**Re: Blackberry House, Berry Lane, Bersted
Erection of a detached dwelling.**

Non-material amendment to planning permission BE/29/10

Project	Sheet
ADC/2/07	
Date	10D
02.11.2011	
Scale	
1:100 @ A1

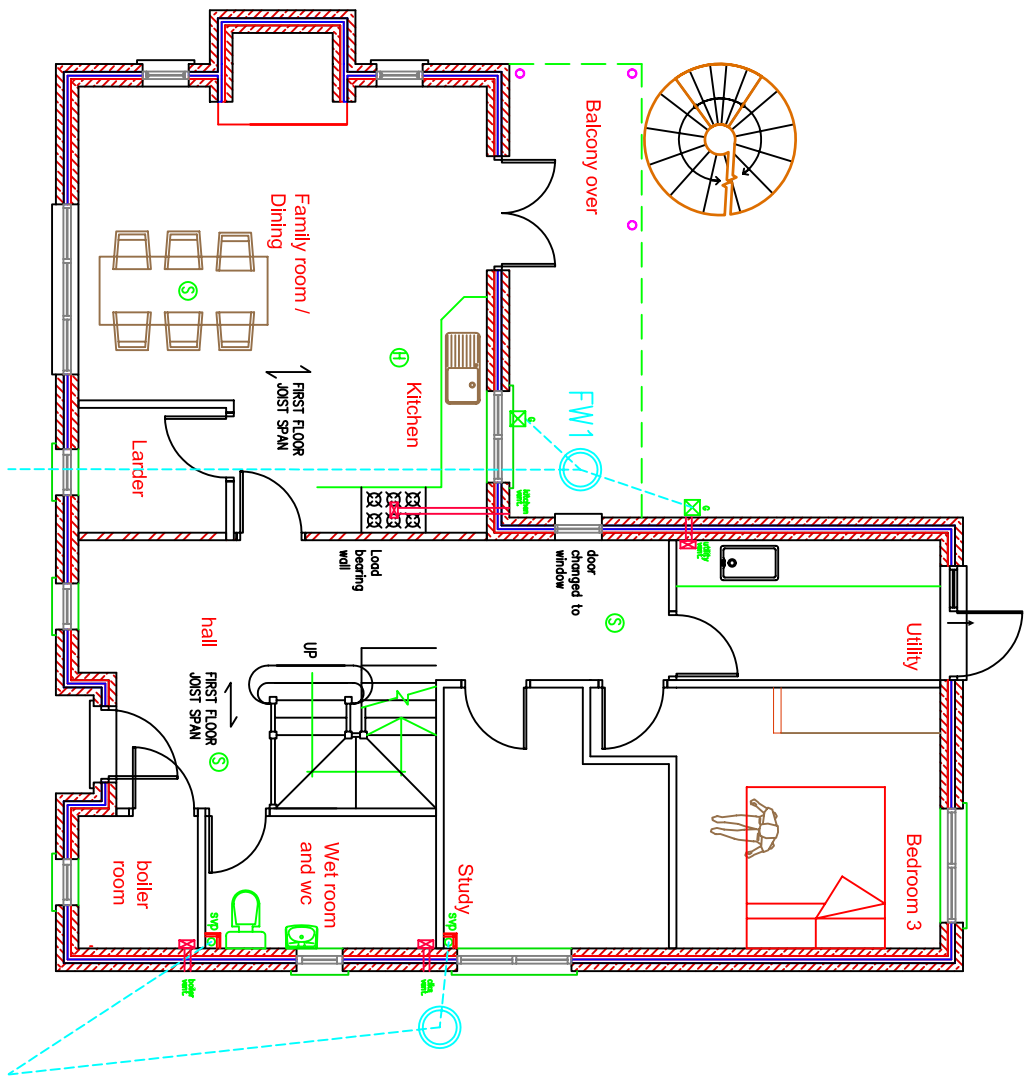
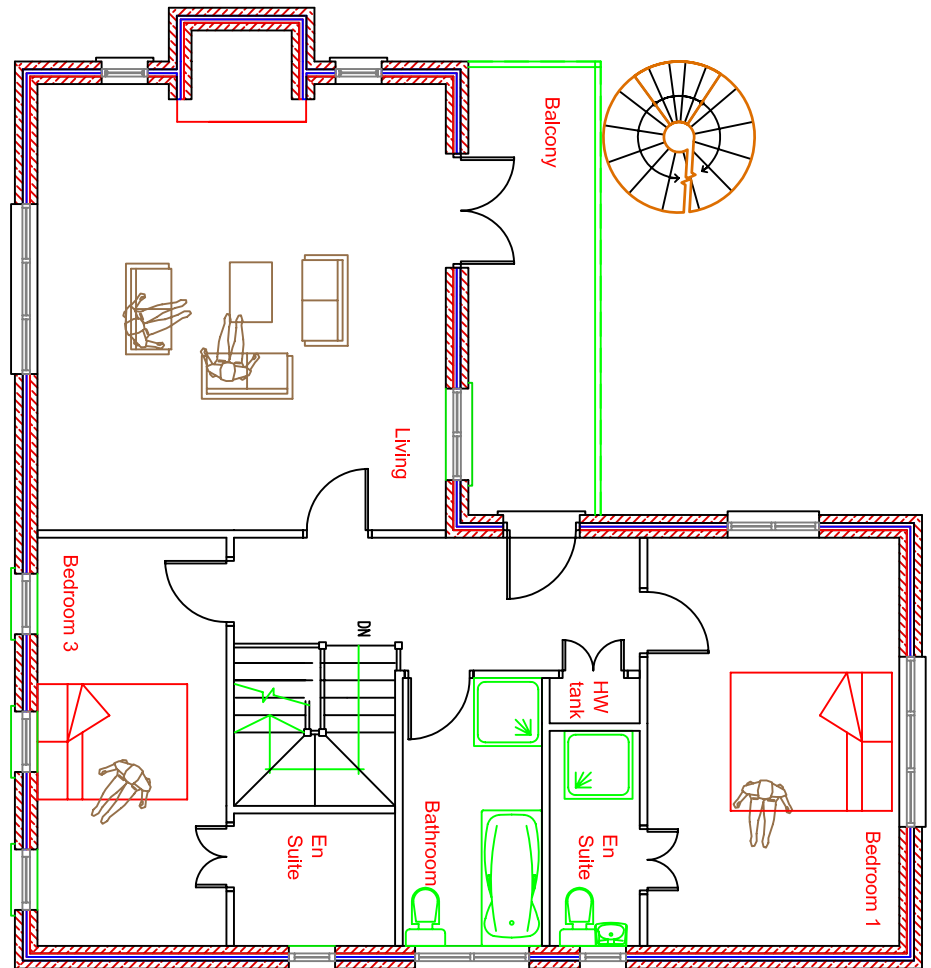
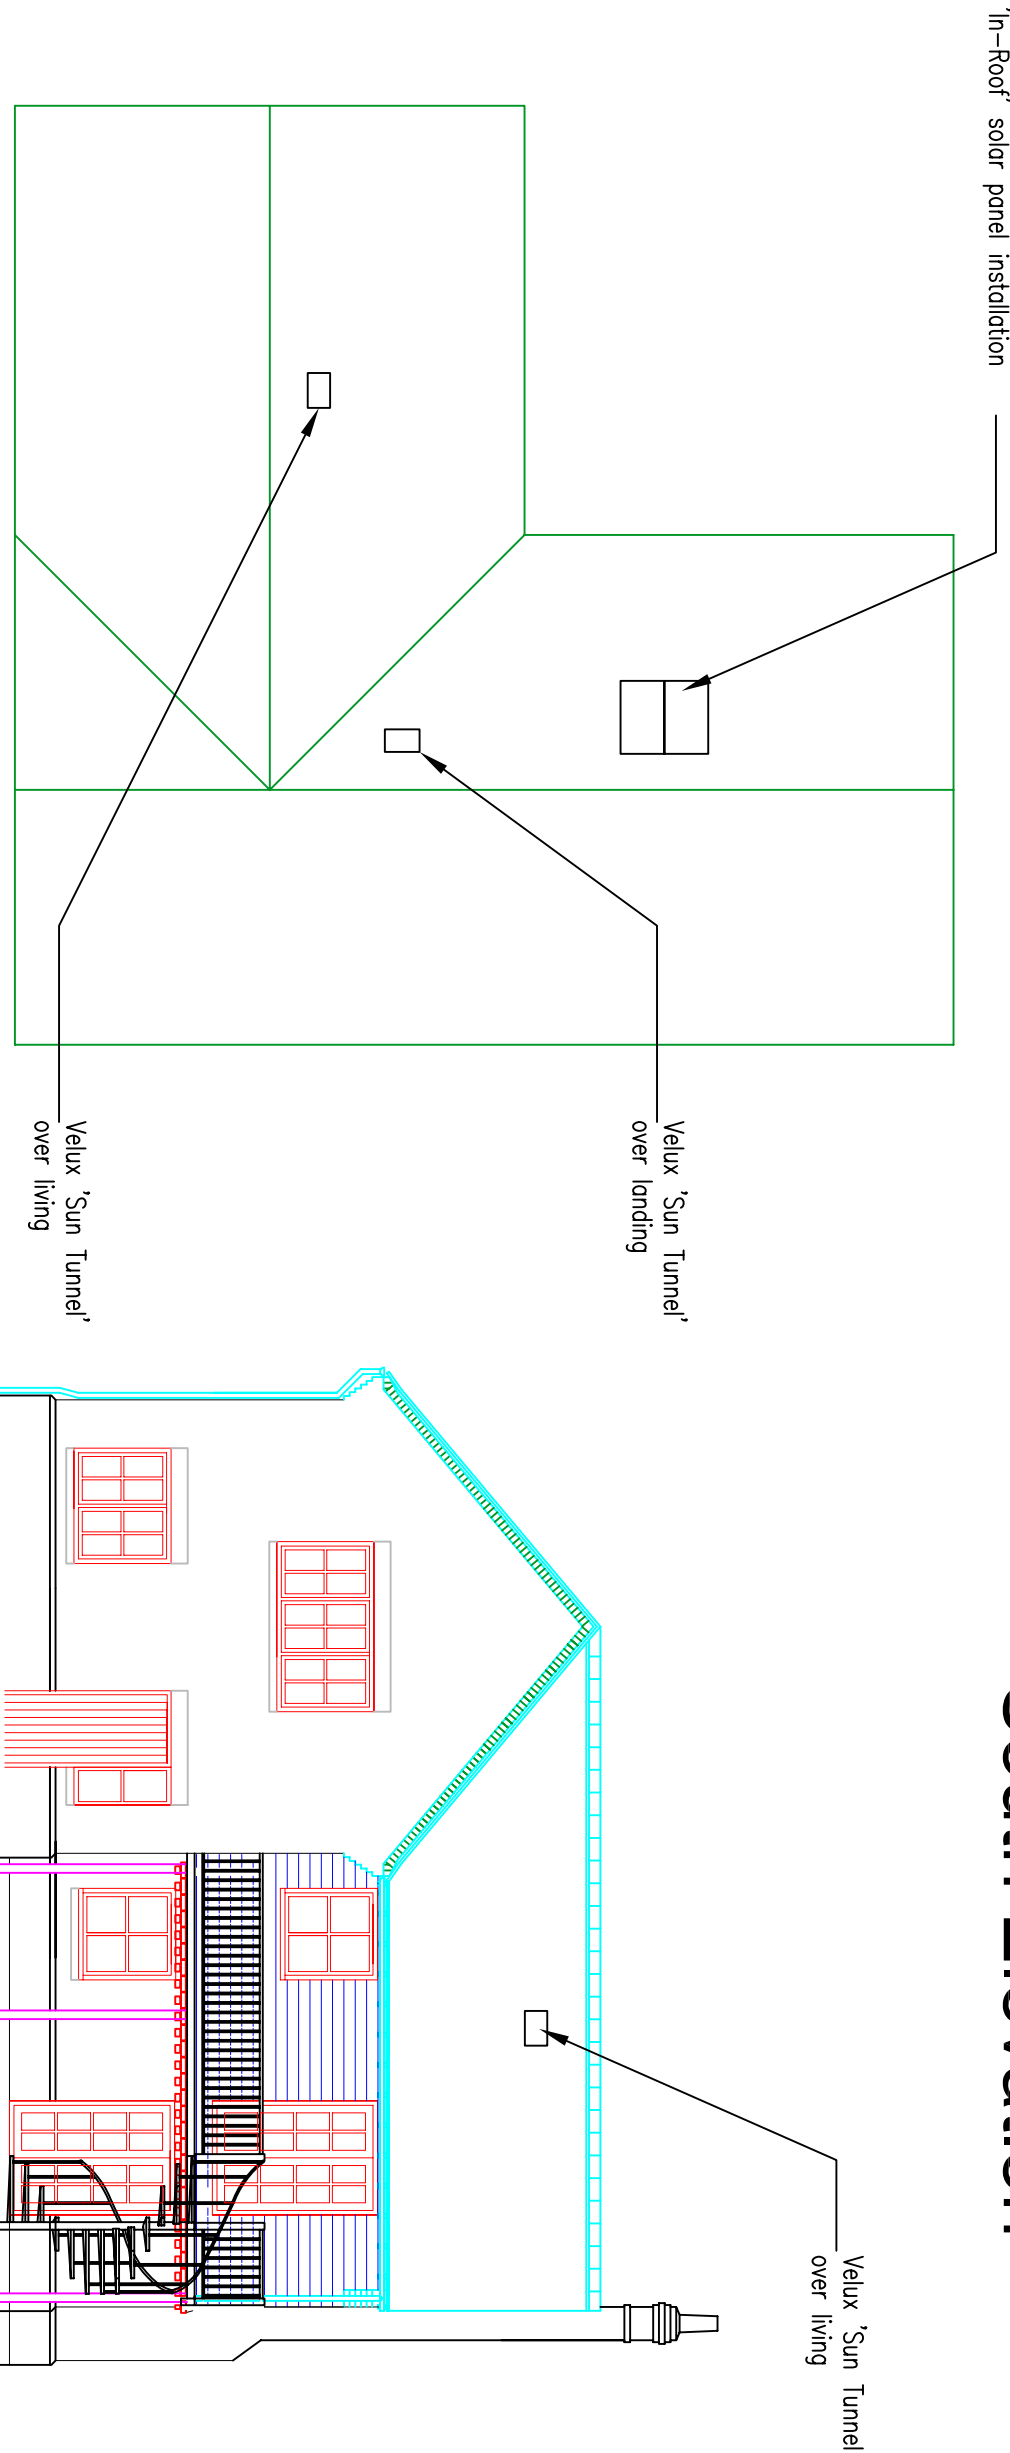
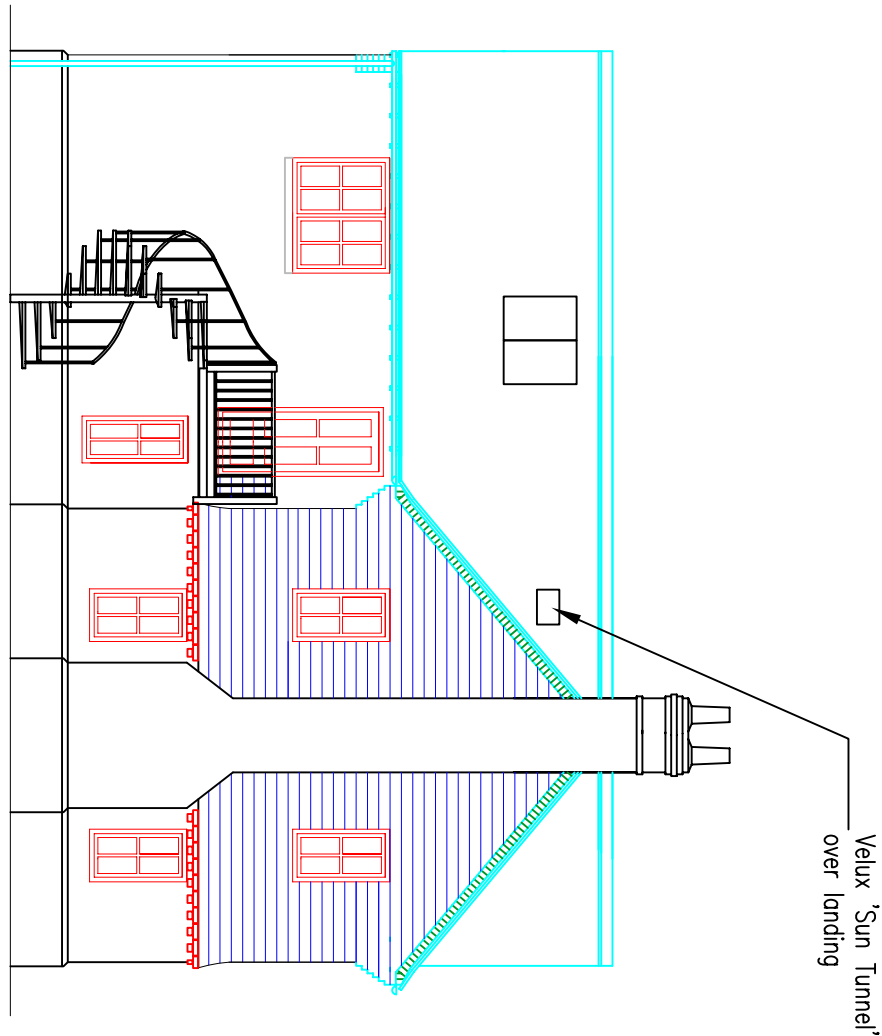
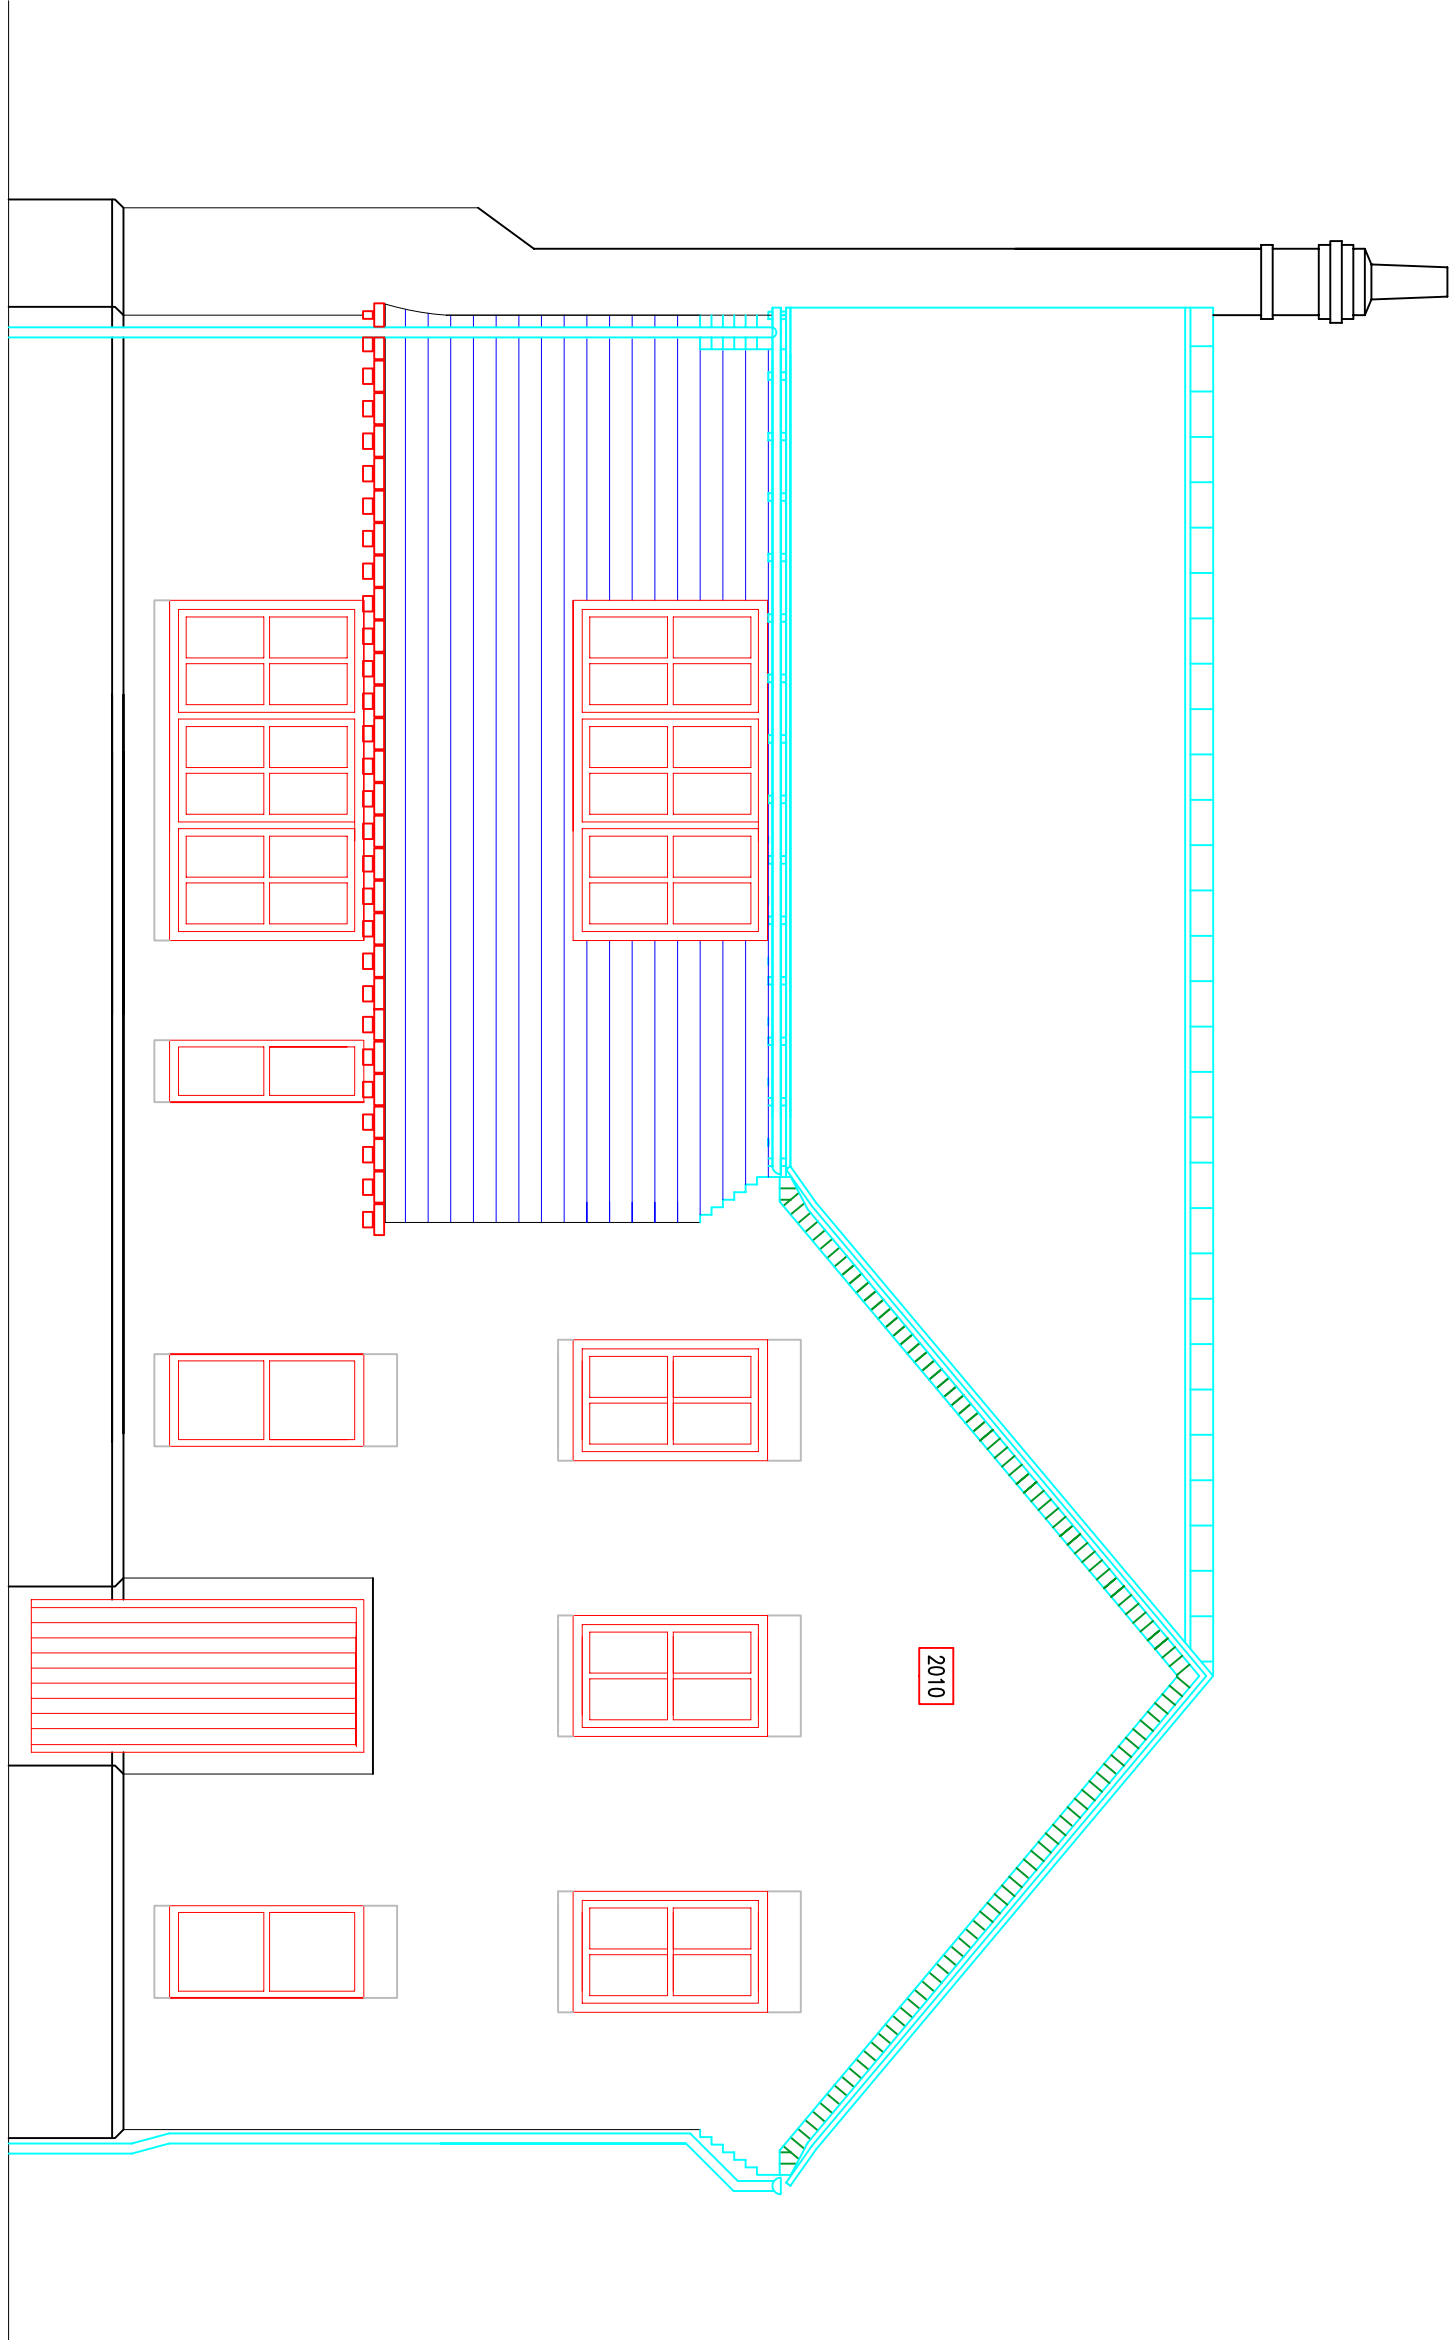
- Internal changes to former wc and the wet room;
- Changing French doors to fully glazed doors;
- Inserting 2no Velux 'Sun Tunnels' - I enclose manufacturer details to assist your consideration of these features - they will be the 014 size [460 x 460].
